**RE: NW Diagnostic Center @ Chaparral Elementary- 1700 Mae Ave. SW
Grading and Drainage Plan
Engineer's Stamp Date 12-18-2014 (File: F10D005A)**

**Re: NW Diagnostic Center @Chaparral Elementary School,
6450 Western Trail NW
Traffic Circulation Layout for Phase 2 Only (5 new portable buildings)
Engineer's/Architect's Stamp dated 01-08-15 (F10-D005A)**

RE: NW Diagnostic Center – Phase 2 @ Chaparral Elementary School
Traffic Circulation Layout (TCL) (File: F10/D005)

**A5** WHEELSTOP SECTION  
SCALE: 1" = 1'-0"

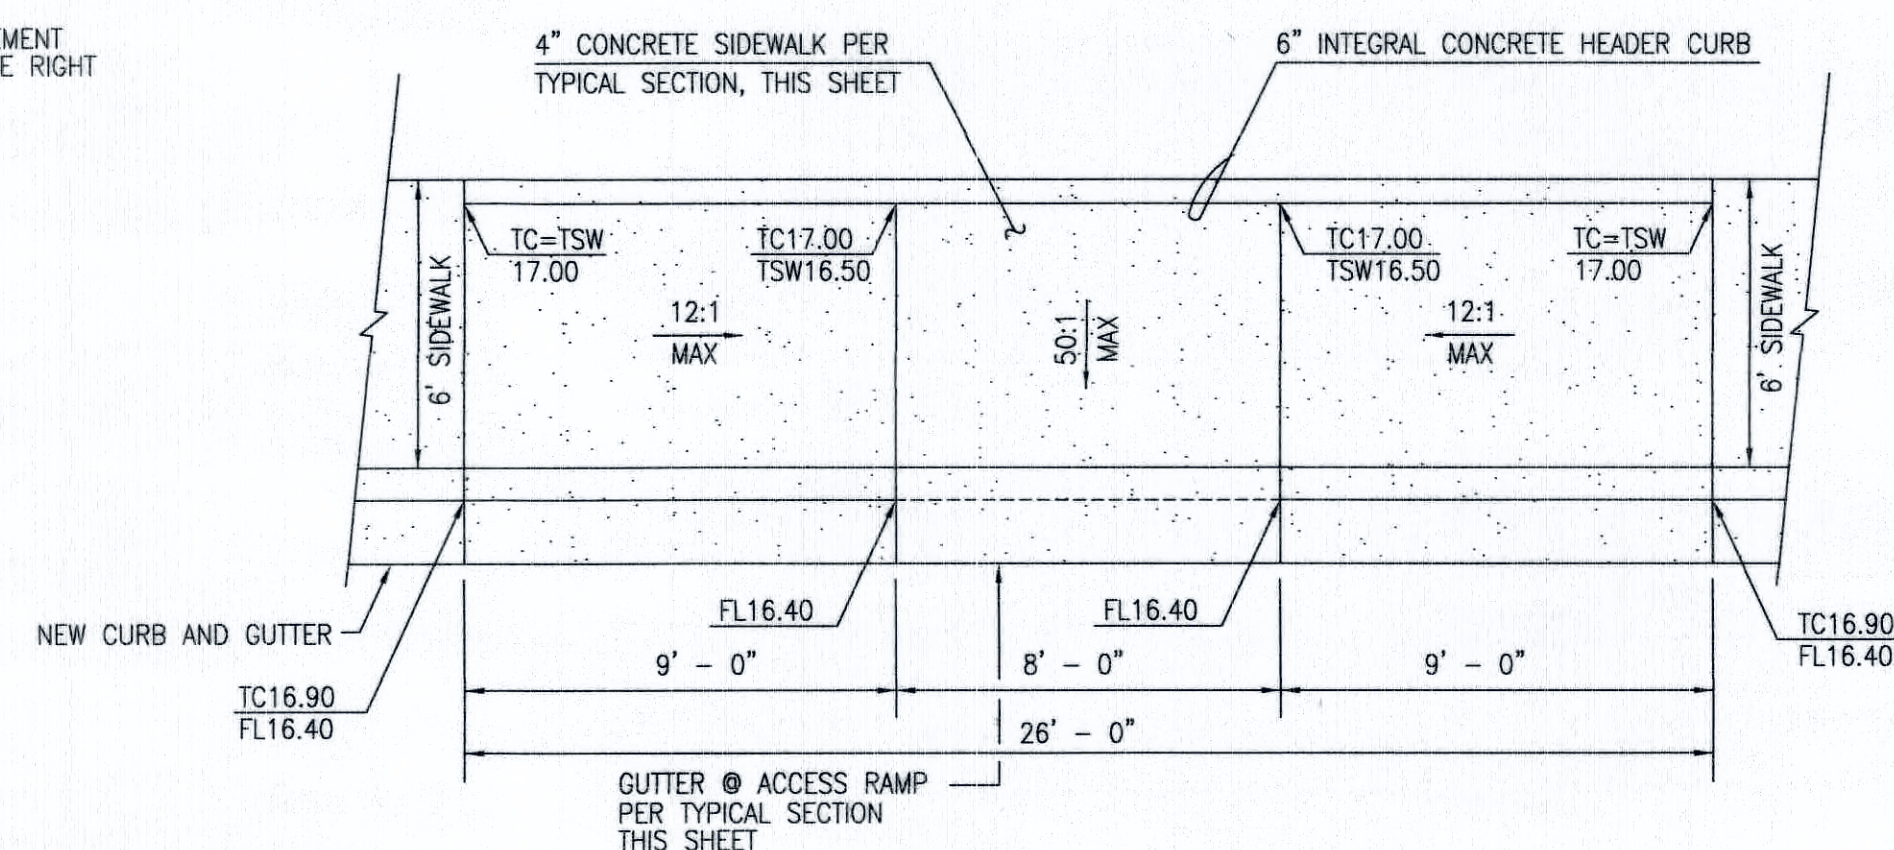
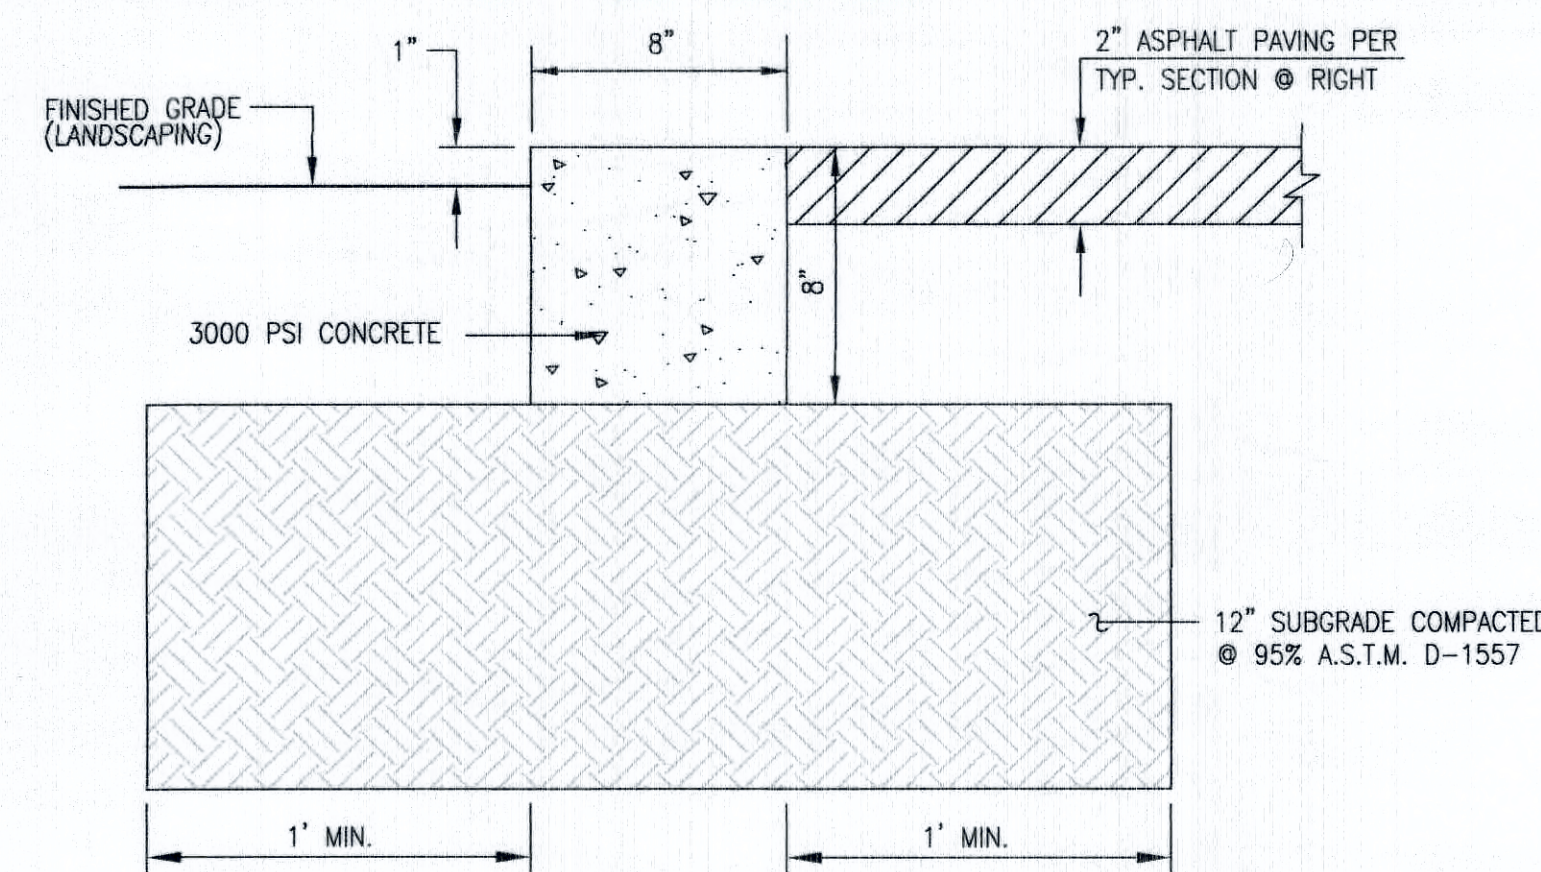
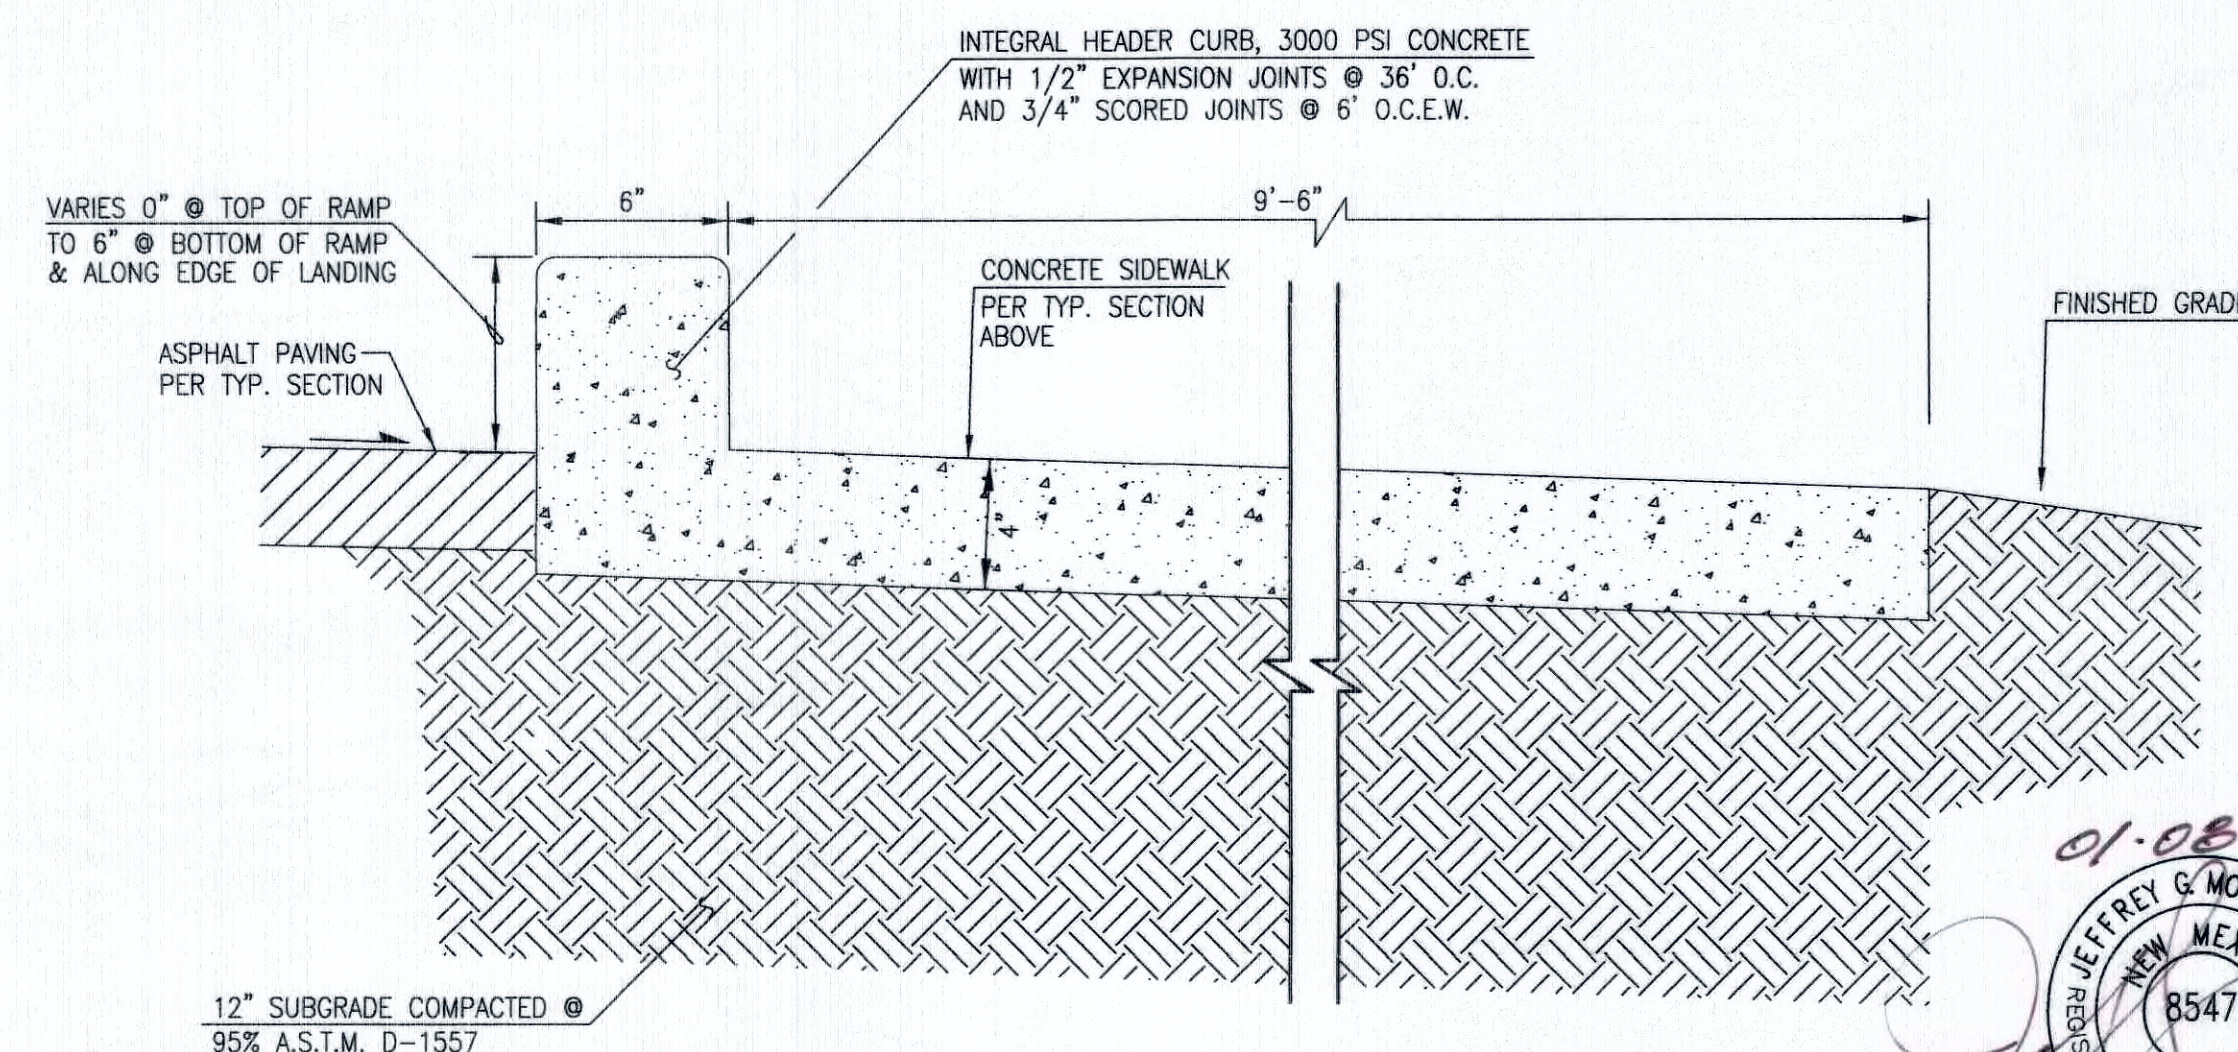
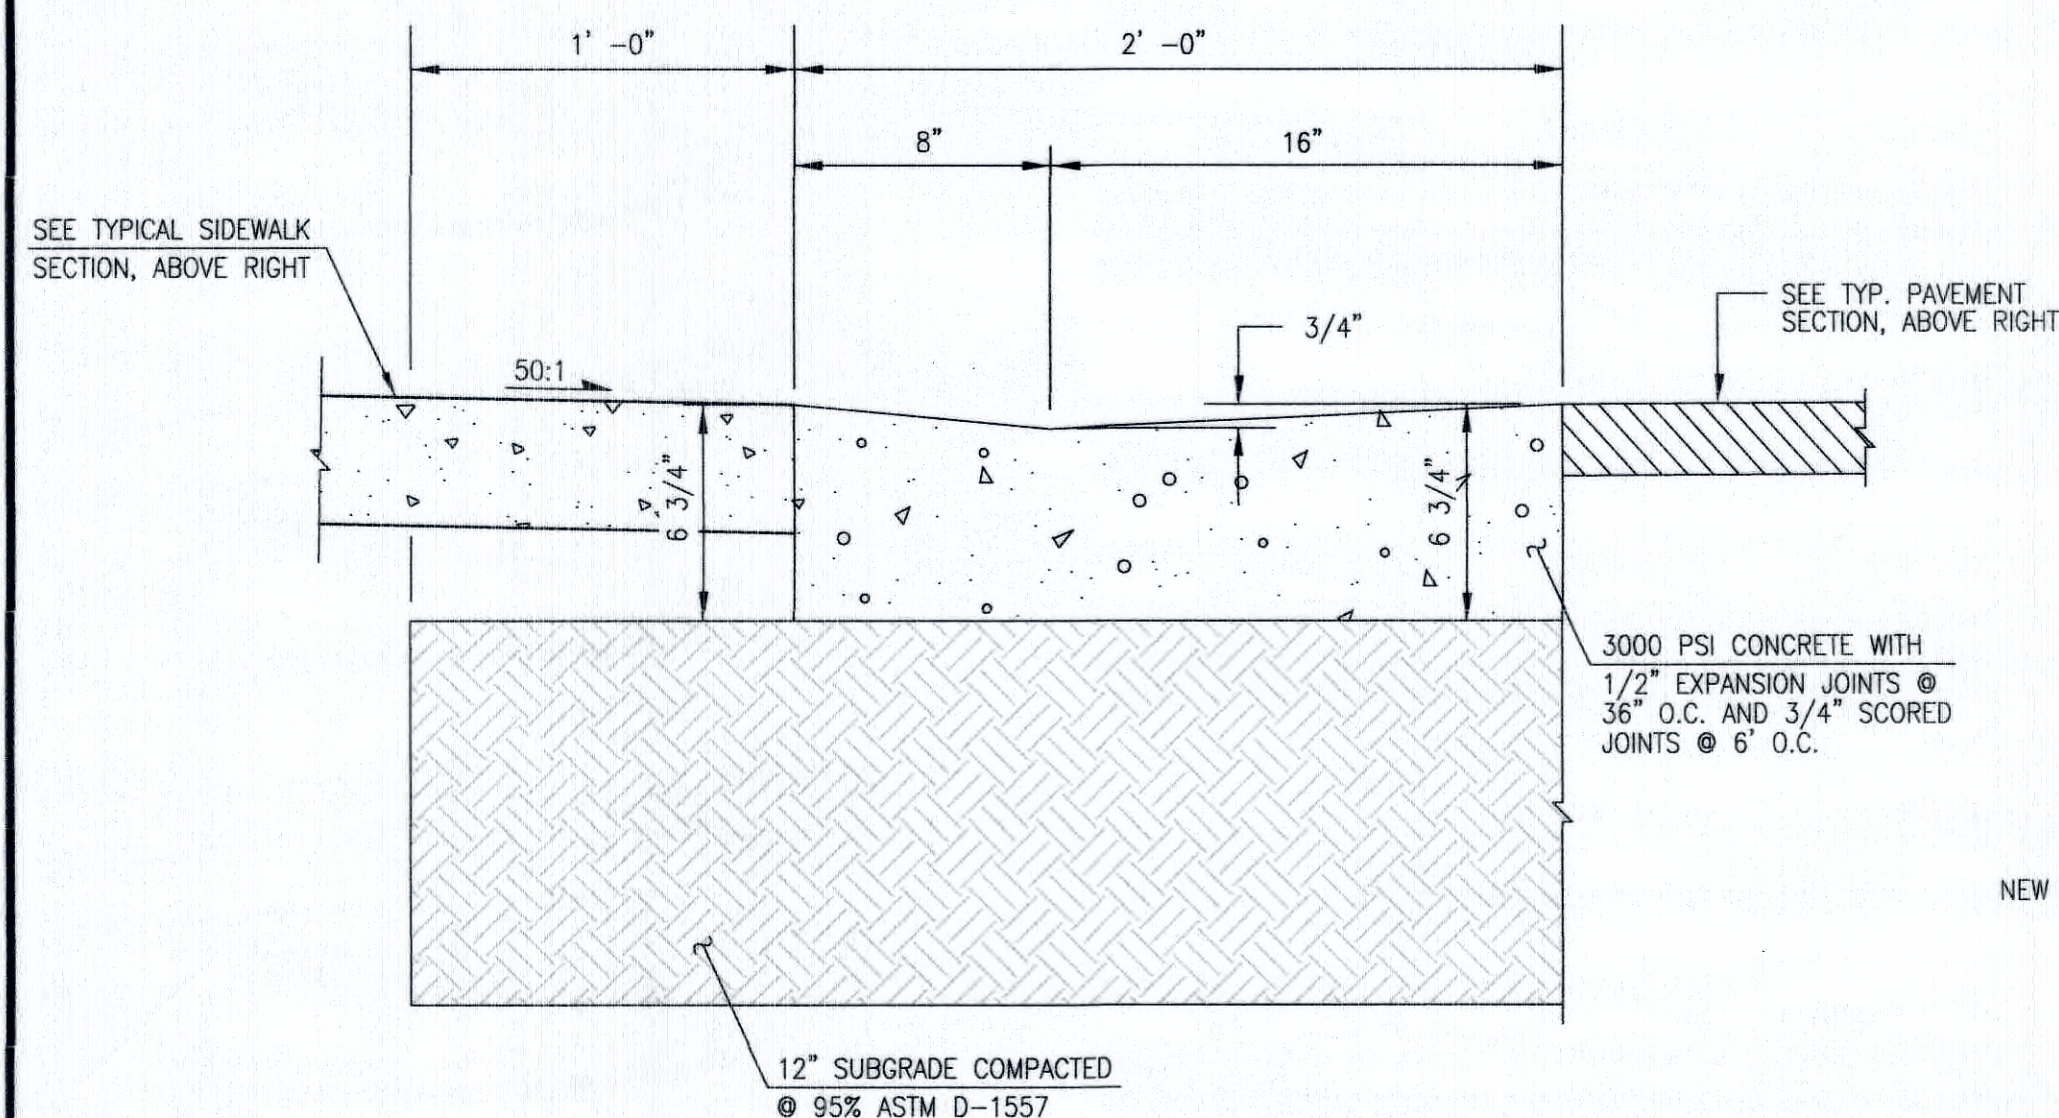
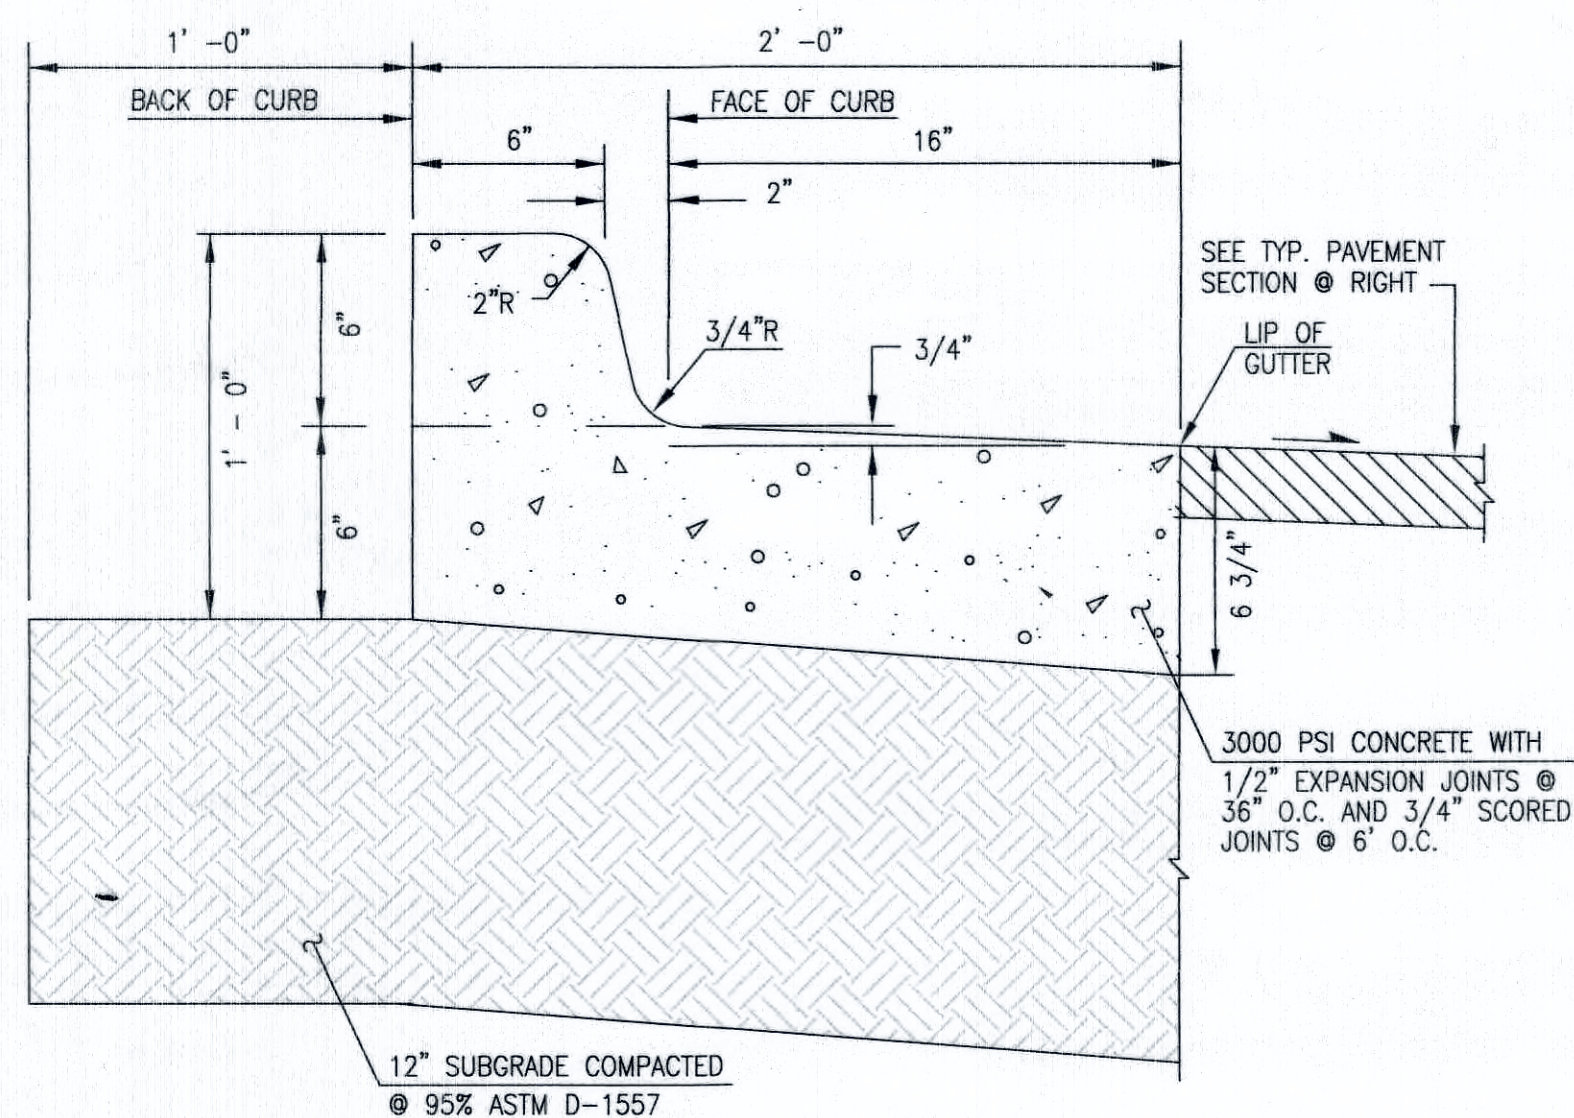
- Minimum lettering height and width dimensions have been added to the **“NO PARKING”** keyed note (Note #29) on the TCL plan.
- 8) Per the DPM, a 6 ft. wide ADA accessible pedestrian pathway is required from the HC parking stall access aisles to all of the building entrances. Please clearly show this pathway and provide language showing that it shall be a 2% maximum required cross-slope. Label the required dimensions for asphalt walkways between buildings, using a minimum dimension of 6 feet when providing ADA access to door entrances.

- The entire courtyard is an ADA accessible pedestrian pathway, and is graded at less than 2% in all directions throughout the entirety of the courtyard, as shown on the Grading Plan (Sheet 8) of the Hydrology submittal. Pathways to each building entrance have been shown graphically on the TCL plan, and denoted to be 6' min width with a 2% maximum cross-slope.

- 9) For all keyed note call-outs on the TCL Layout (Sheet 5) referring to details on Sheet 6, call out the exact number of the detail to be clear.
 - All keyed note call-outs on the TCL Layout that refer to Sheet 6 details now include the exact number of the detail and section for clarity.
